# CITY OF ALBUQUERQUE

October 23, 2019

**Re: Chipotle**  
**4331 San Mateo Blvd NE Albuquerque NM 87110**  
**Traffic Circulation Layout**  
Engineer's/Architect's Stamp 10-16-2019 (G17D032)

Site Plan

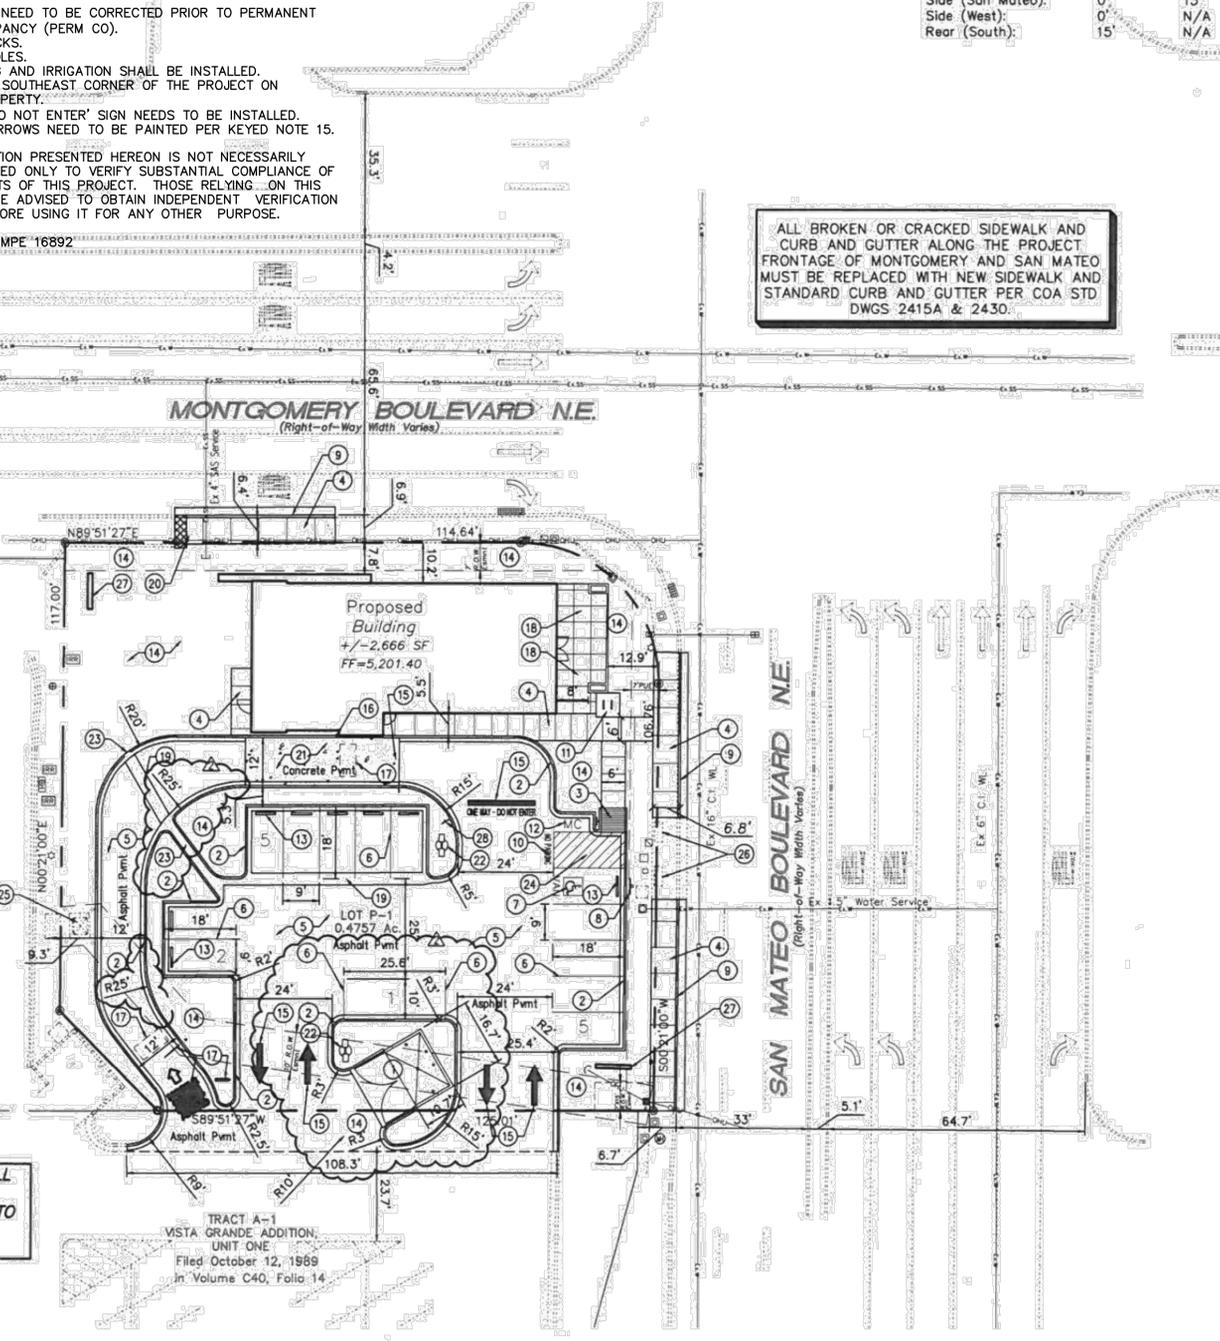
1. Refuse vehicle maneuvering shall be contained on-site. The refuse vehicle shall not back into the public right of way.; **provide a copy of refuse approval.**
2. Show the clear sight triangle and add the following note to the plan:  
"Landscaping and signage will not interfere with clear sight requirements. Therefore, signs, walls, trees, and shrubbery between 3 and 8 feet tall (as measured from the gutter pan) will not be acceptable in the clear sight triangle.
3. Shared Site access: driveways that straddle property lines, or are entirely on one property but are to be used by another property, shall have an access easement. Please include a copy of your shared access agreement with the adjacent property owner.
